A/Director Regional Projects  
Department of Planning and Infrastructure  
GPO Box 39  
SYDNEY NSW 2001

**Re: MP09\_0166 Environment Assessment "Altitude Aspire", Fraser Drive,  
Terranora TWEED LGA**

Thank you for your letter of 21 February 2011 requesting comment from the Department of Primary Industries (DPI) on the Environmental Assessment (EA) for the above mentioned major project. DPI also appreciates the granting of an extension of time for this response.

GJ0901.1.5a

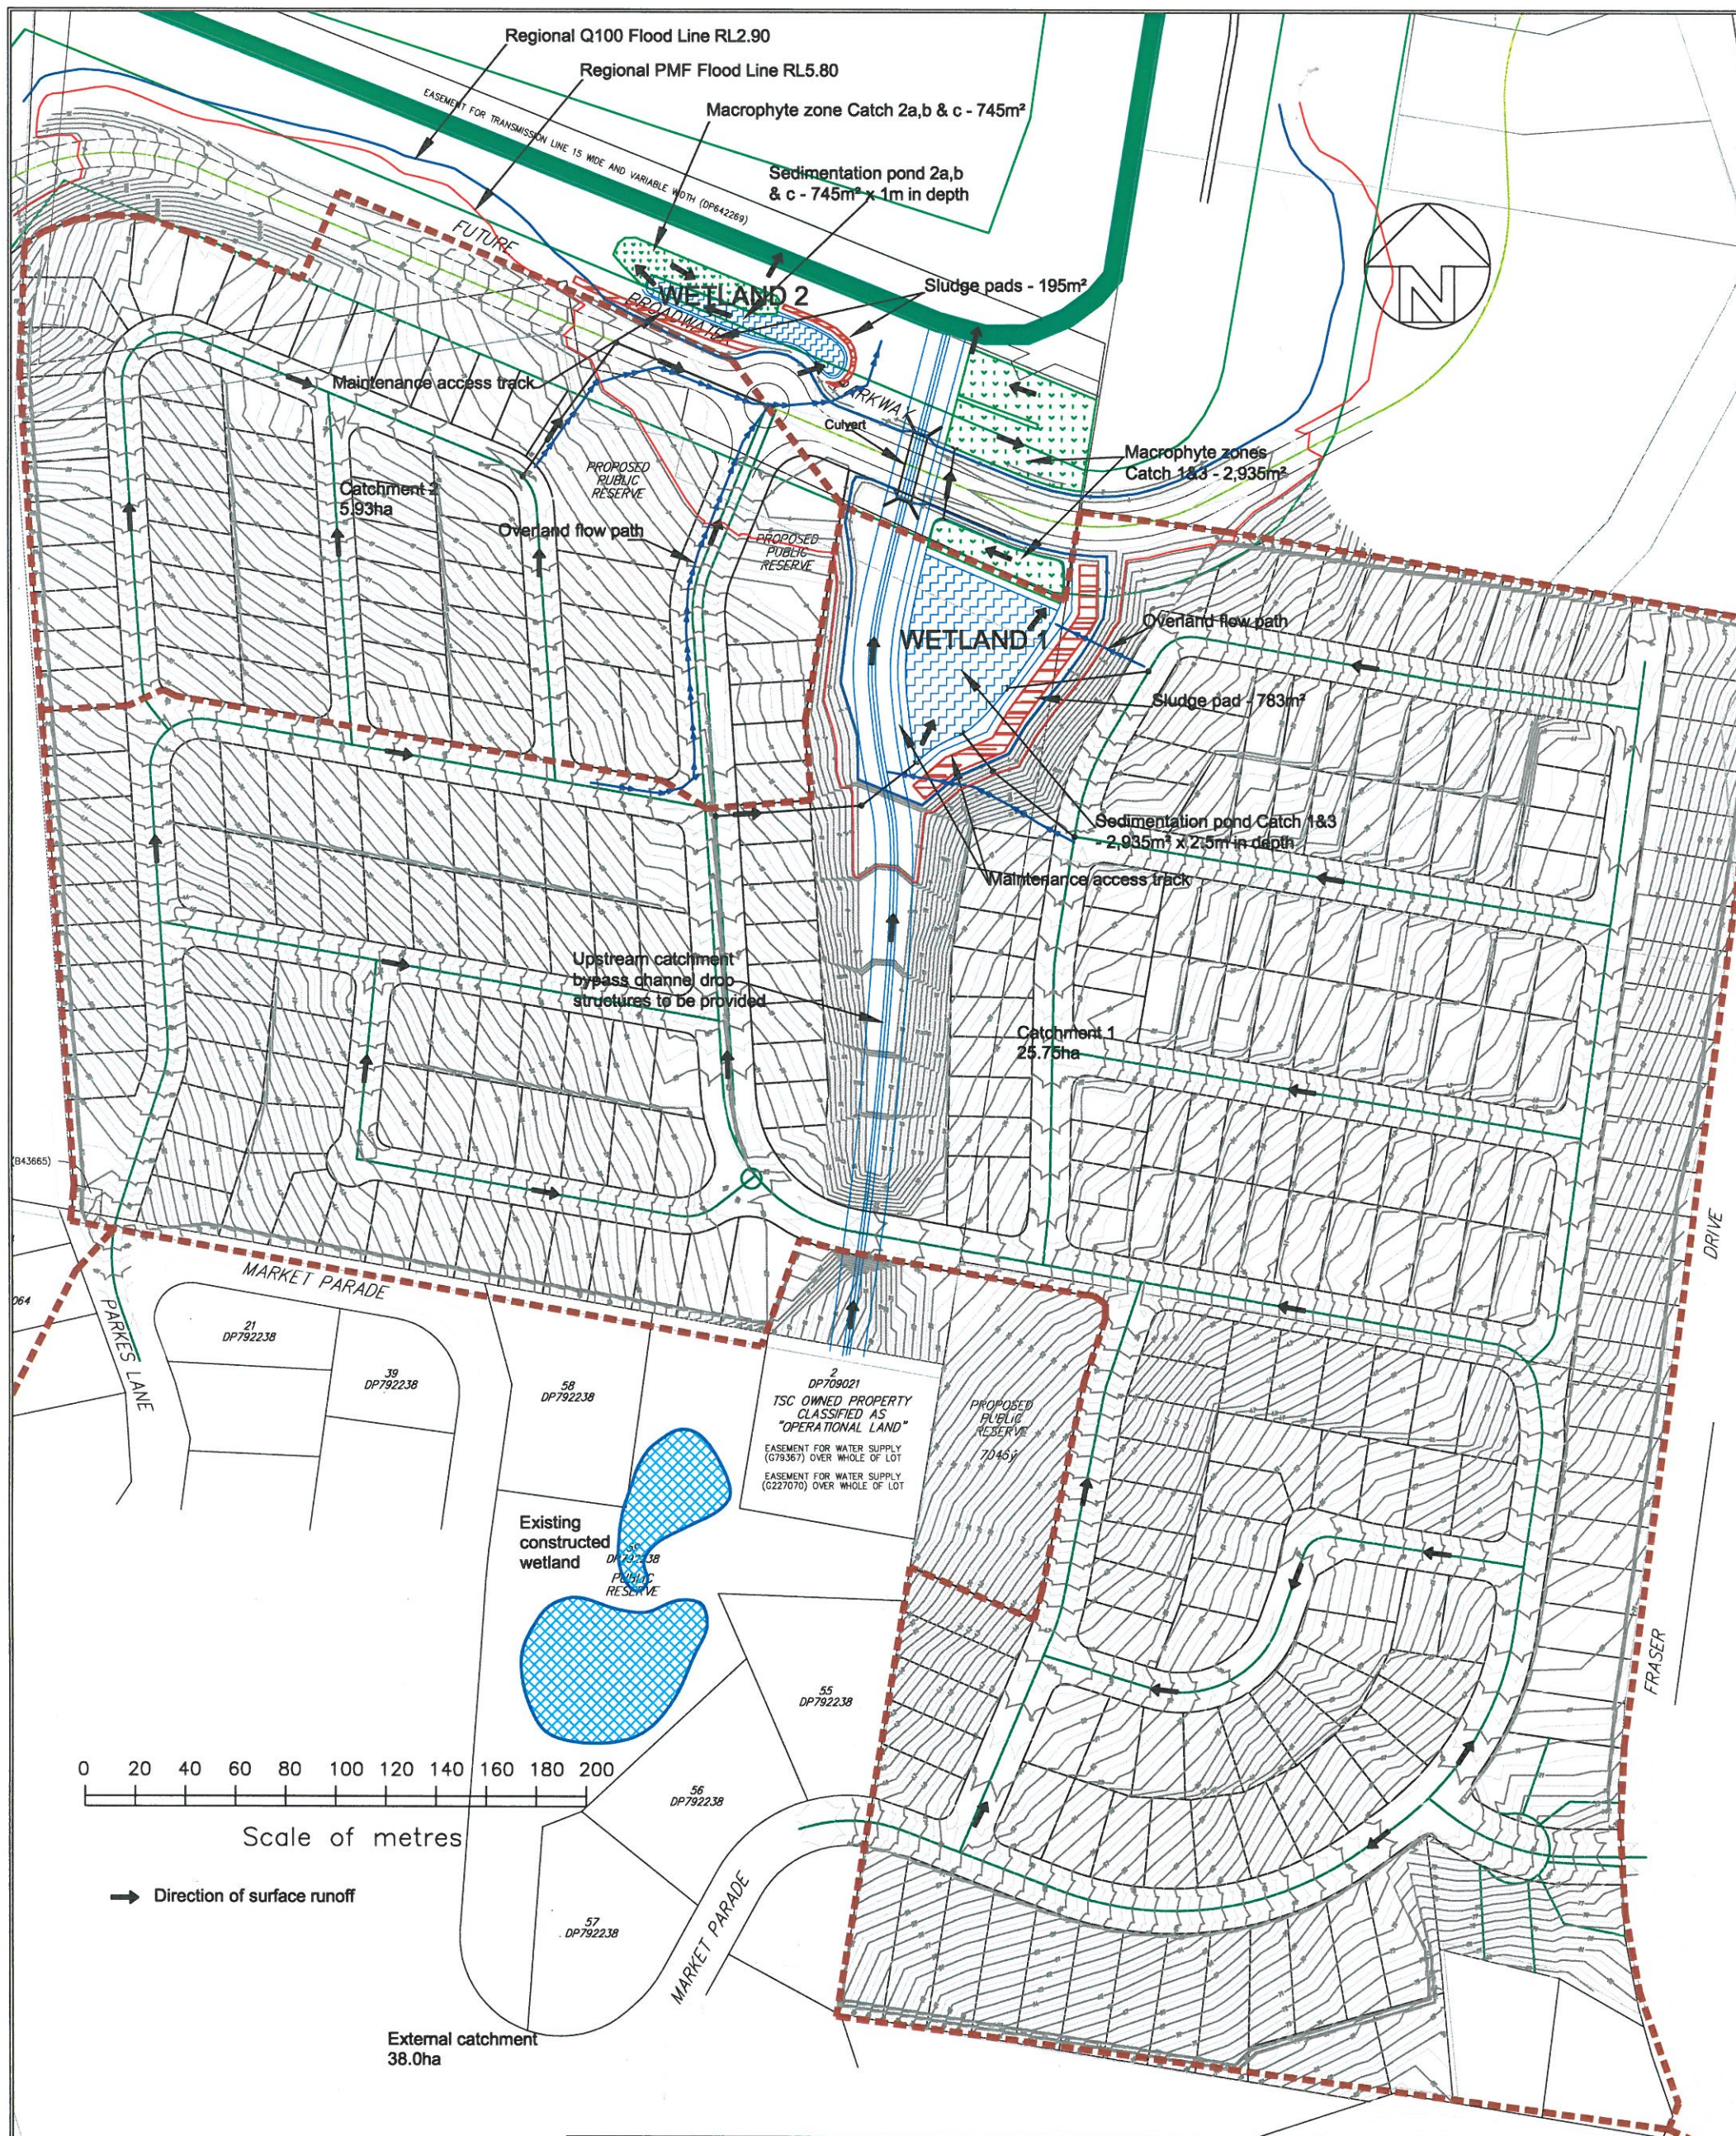
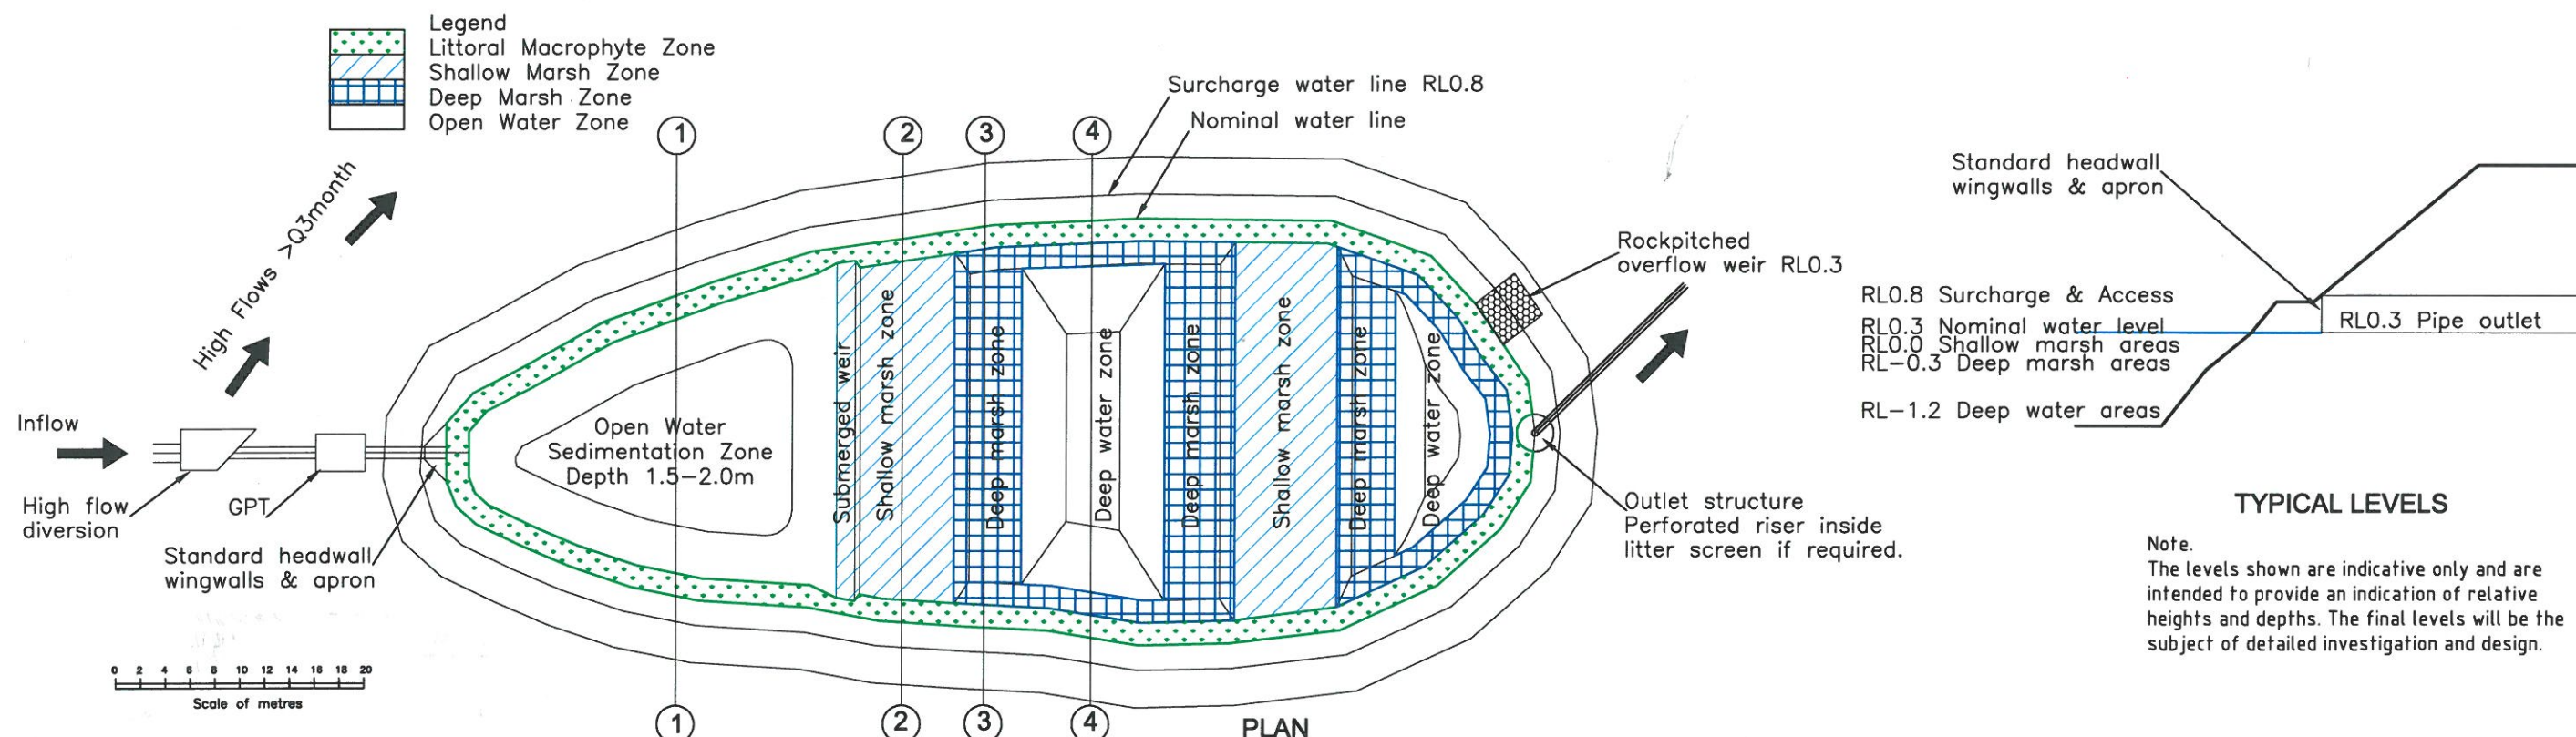
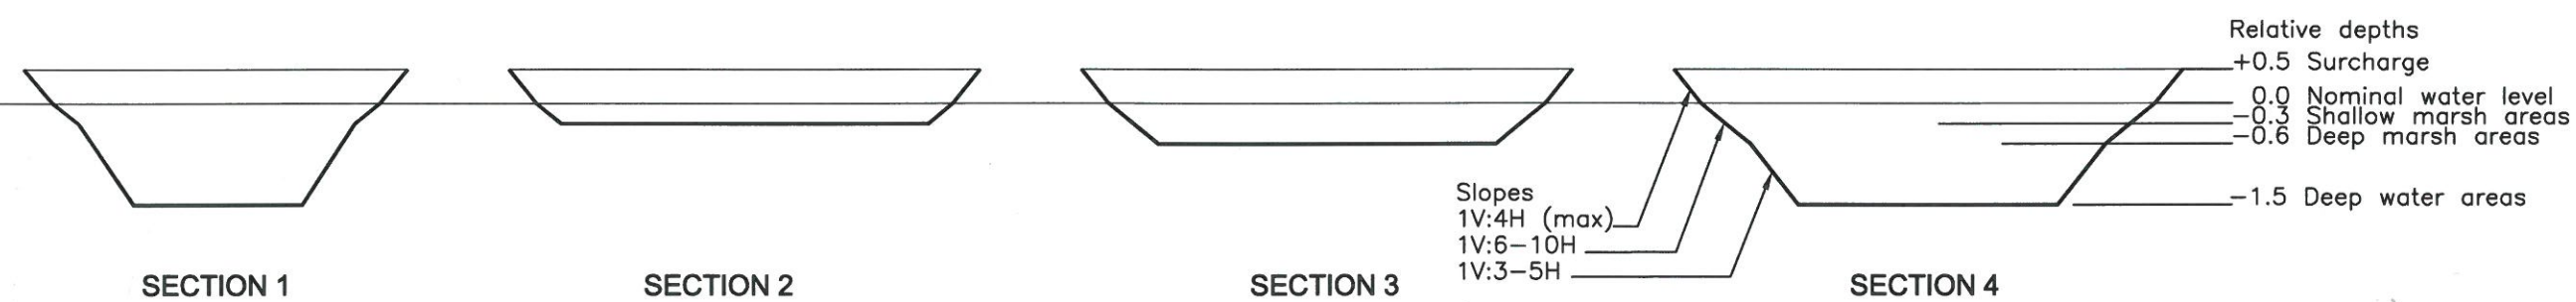
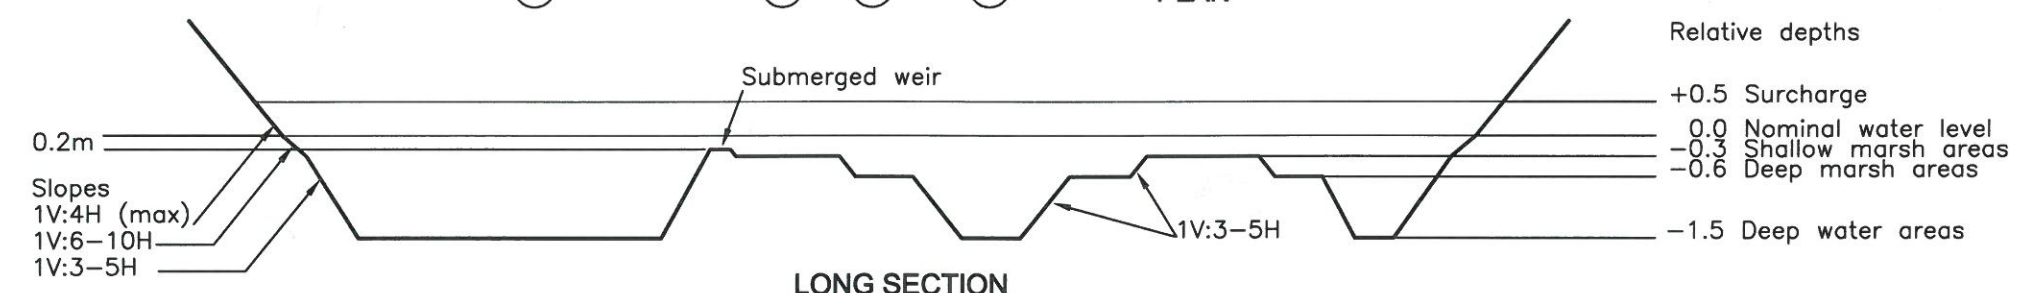
In addition to the proximity of proposed stormwater management features to the SEPP 14 Coastal Wetland being inconsistent with DPI buffers policy, their positioning in an area of elevated groundwater may compromise the operation of these features.

DPI is also concerned about the limited amount of detail within Appendix 14 of the stormwater management plan within the EA. Where detail is provided, certain performance criteria do not achieve basic water quality standards.

For instances the stormwater management plan proposed minimum release criteria at the site for pH of >5.0. Firstly this level is inconsistent with the EA's own Acid Sulfate Soil Management Plan which requires pH 6.5. Secondly, the NSW Oyster Industry Sustainable Aquaculture Strategy (SEPP 62) sets the lower threshold for pH in oyster aquaculture areas as pH 6.75. The upper threshold is 8.75. It should be noted that SEPP 62 captures and has relevance to this proposal as the development site is within 10km of Priority Oyster Aquaculture Areas. Furthermore, the Office of Environment and Heritage's water quality objectives for the protection of aquatic ecosystem health within Terranora Broadwater sets a trigger value within the estuary of pH 7.0 with an upper threshold of pH 8.5.

DPI strongly recommend the stormwater management plan require that a pH range between 6.75 and 8.5 be achieved prior to discharge considering the SEPP 14 Coastal Wetland and the proximity of SEPP62 Priority Oyster Aquaculture Areas to the north at Birds Bay. The stormwater management plan should also, at a minimum, include contingencies for scenarios where it appears that treatment measures are ineffective in meeting pollution discharge targets.
